**Our ref:** 23\_25898\_P

**Your ref:** H16-1096-23

**Site Location:** Land between A16 and Rangell  
Gate Spalding

**Summary of Proposal:** Proposed  
Anaerobic Digester Plant

Drawing file: H16-1096-23 / 3899B PROPOSED SITE PLAN  P01.pdf

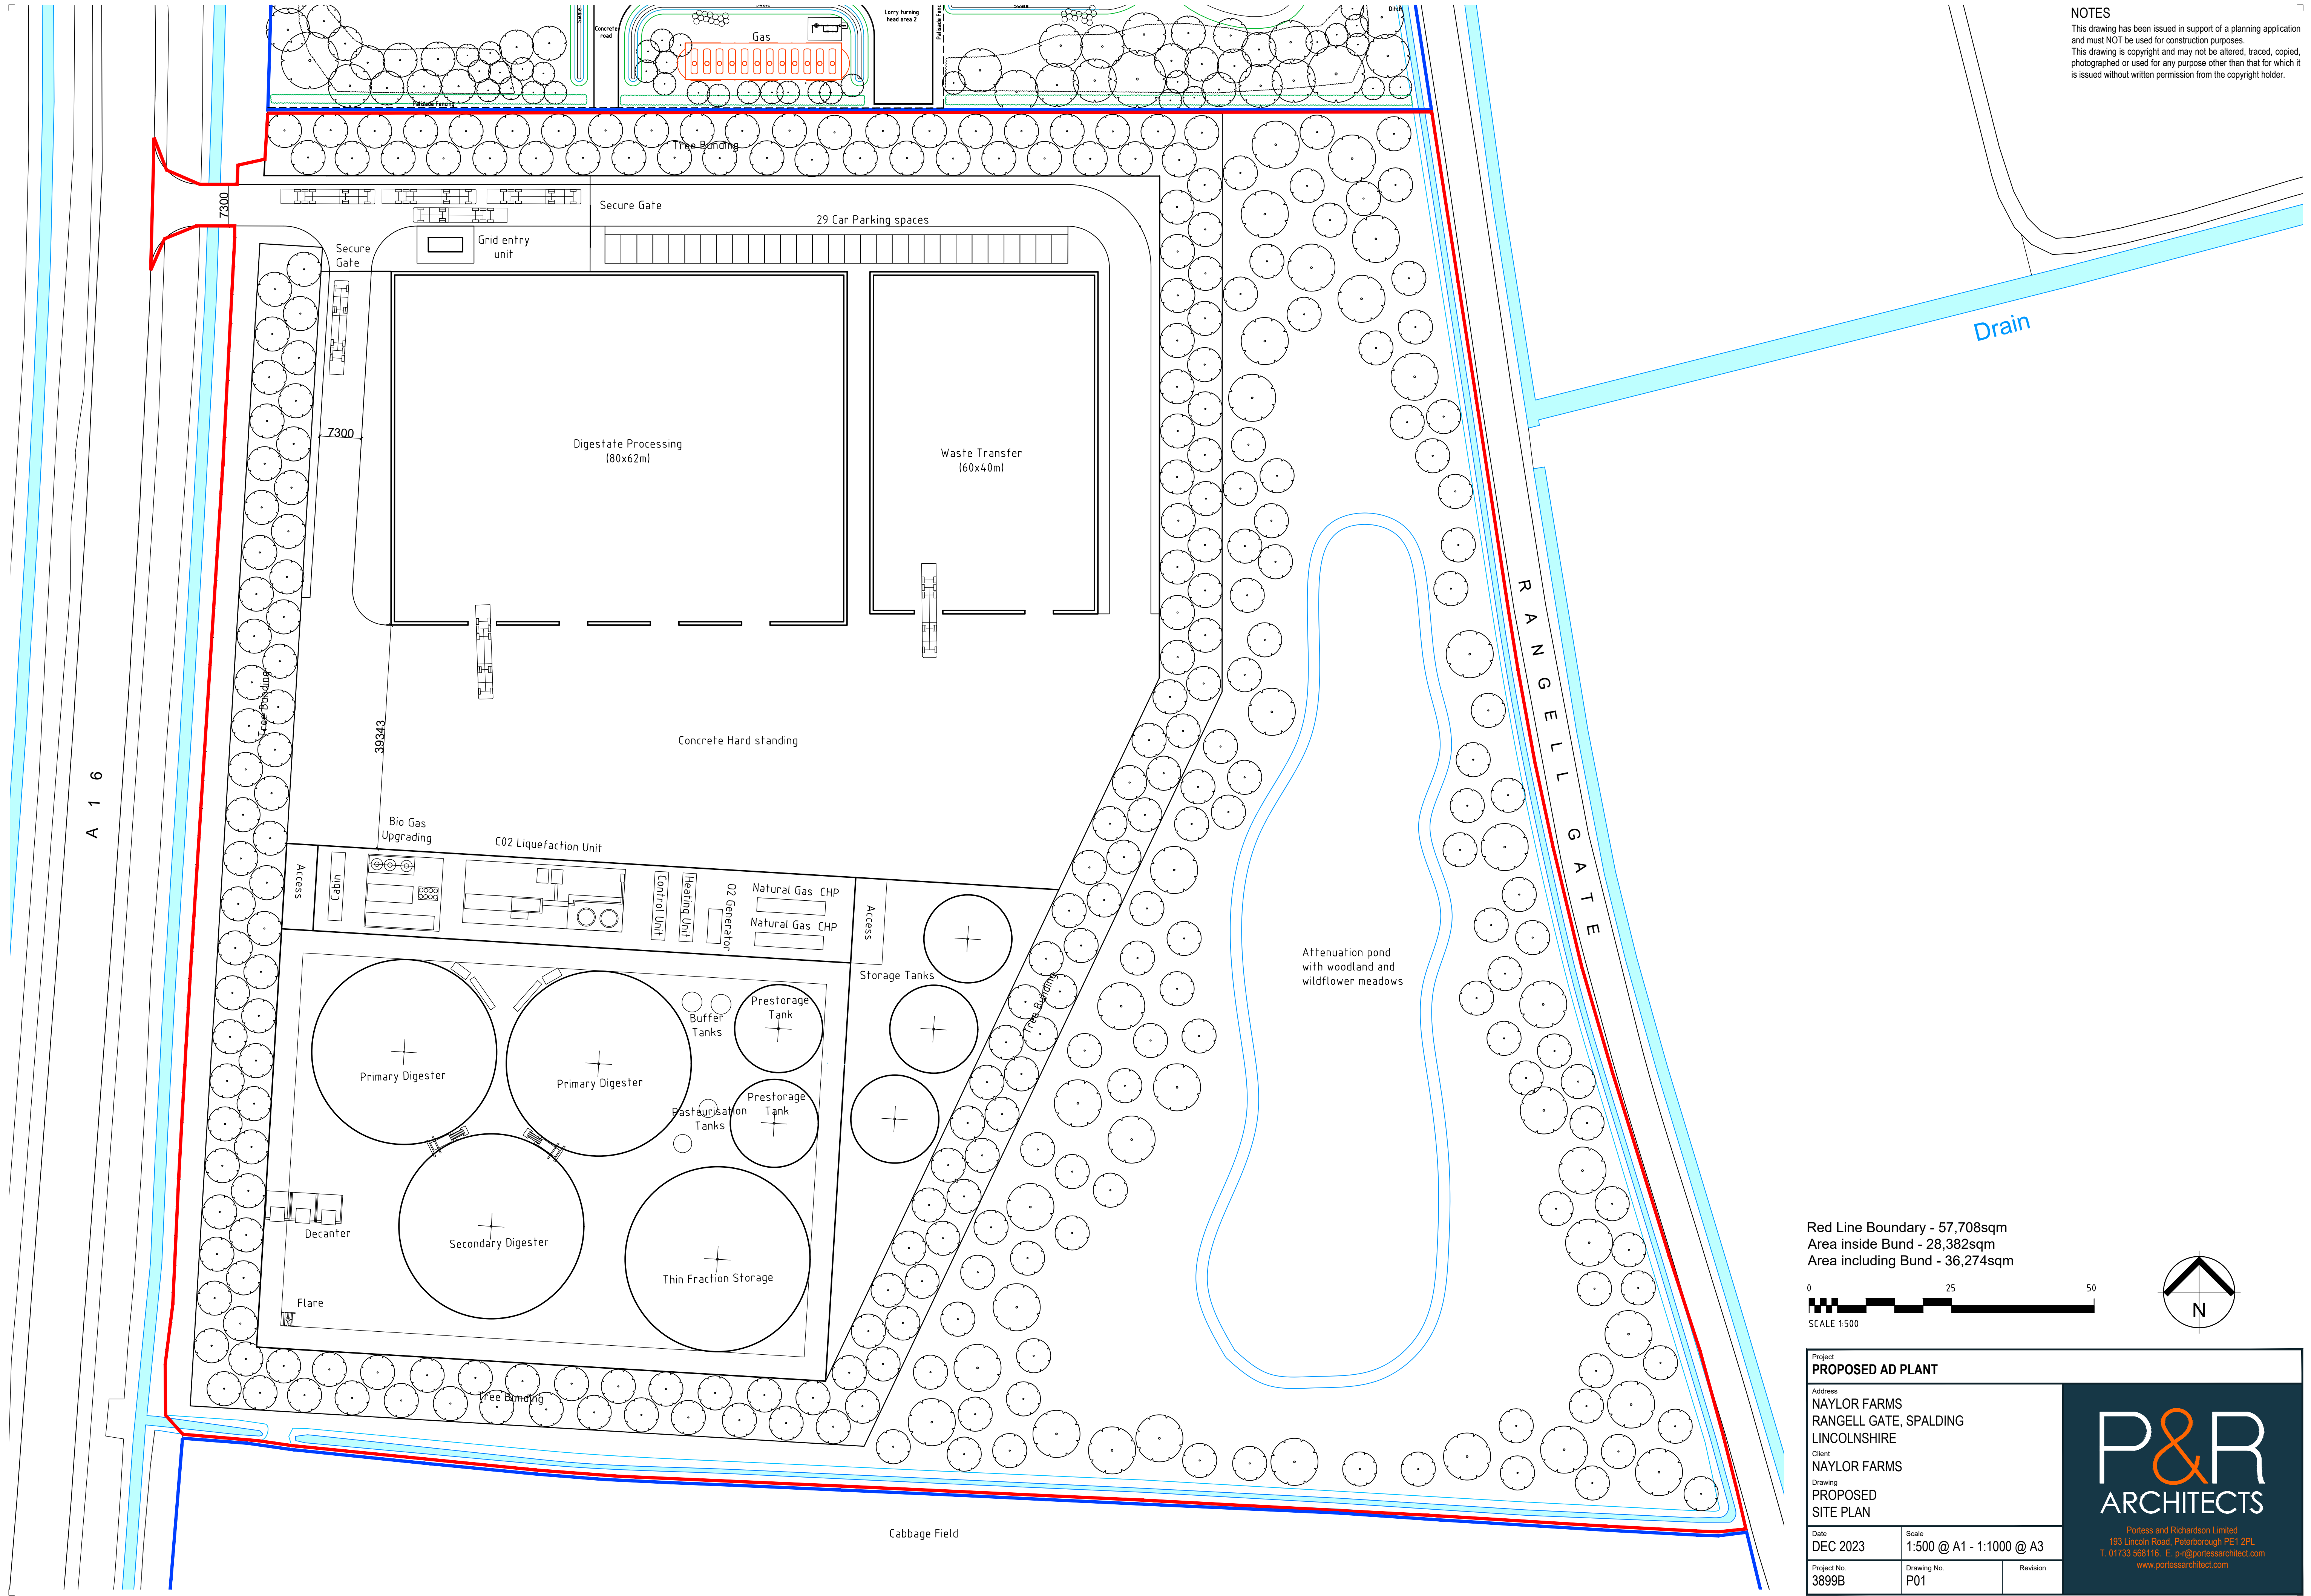
I note the site is surrounded by riparian watercourses which are not maintained by the Board (ordinary watercourses), adjacent to each site boundary. I note that the applicant intends to install a 7.3 metre access off the A16 across the riparian watercourse to the west of the site (Proposed Site Plan, Drawing ref: 3899B P01, Portess & Richardson Ltd., December 2023).

Whilst the applicant has not provided further details on the proposed crossing, should this proposal involve altering the watercourse (including installing a culvert), prior written consent is required from the Board under Section 23 of the Land Drainage Act 1991 (and byelaw 4). The Board requests further information is provided.

The Board recommends that adequate space (3-5 metres) is left flat and free from obstruction adjacent to the riparian watercourses, in order to enable maintenance by future riparian owners.
